# HERTSMERE BOROUGH COUNCIL

## Application for a Non-Material Amendment Following a Grant of Planning Permission

23/0110/FUL

2208-PL-013-P2 72 Park Crescent - Proposed elevations

Zone: X	Drawn By: MBT	Discipline: AR
	Checked By: MBT	
Drawing No: 2208-PL-013		Rev: P3

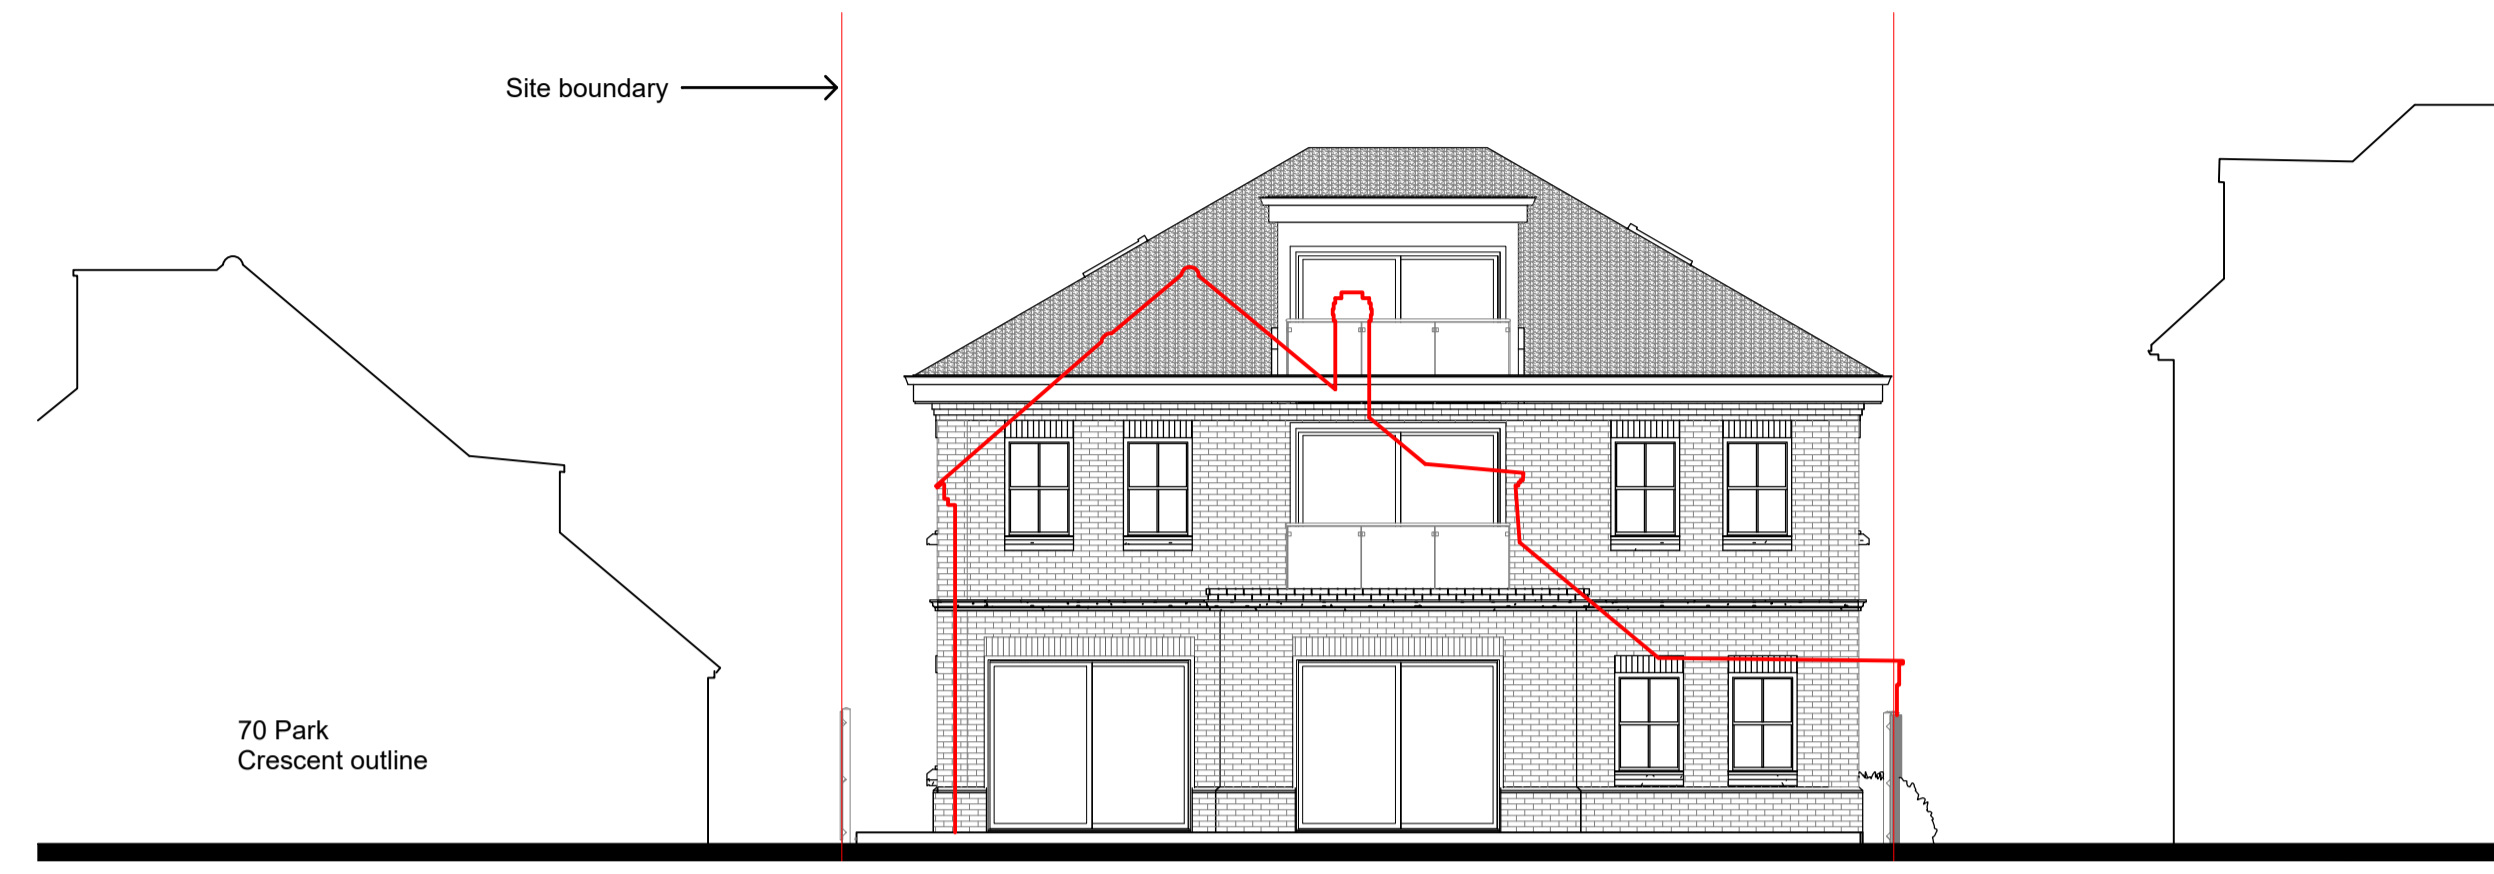
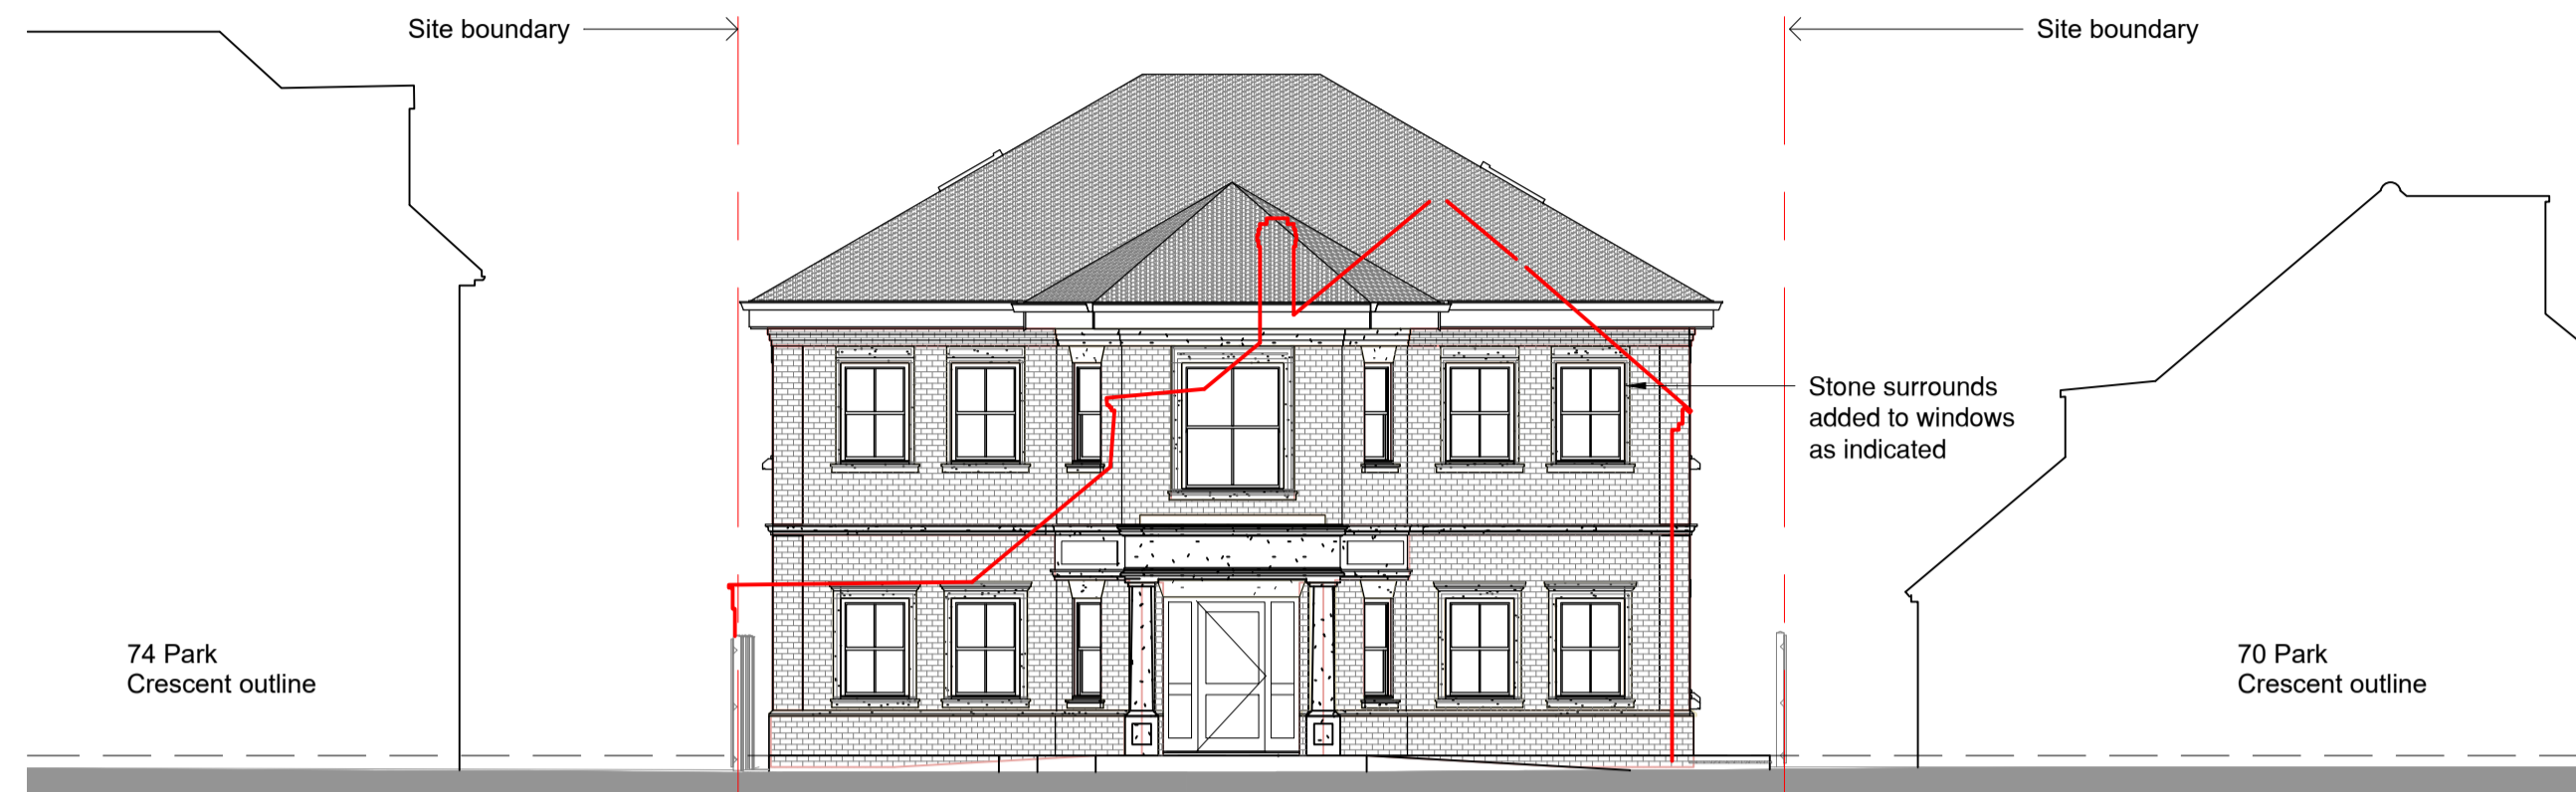
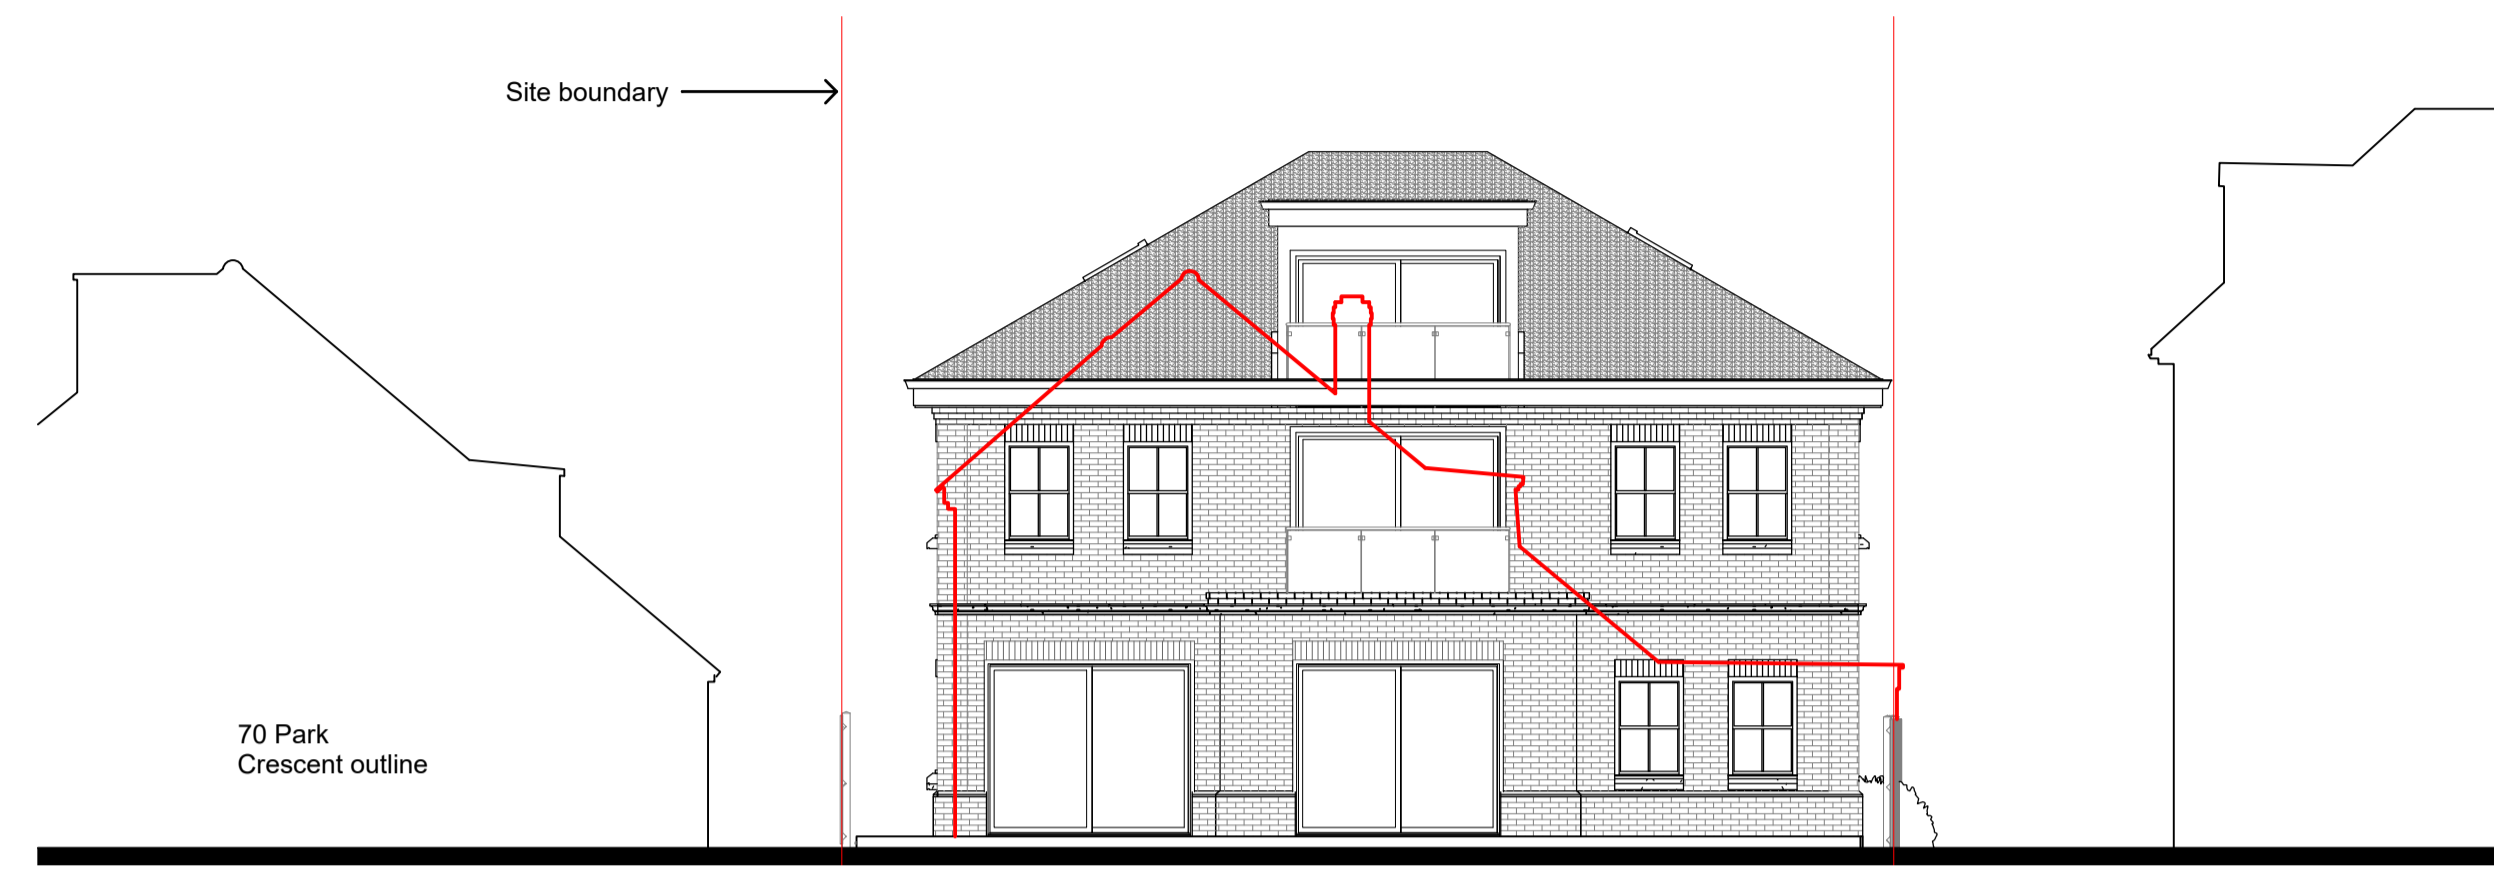
Stone surrounds added to nine windows on front elevation - Using same stone already approved for cills and false lintels at heads in consent 23/1392/DOC

Improvement to the original appearance decided on during design development post planning.

2208-PL-013-P3 72 Park Crescent - Proposed elevations amended
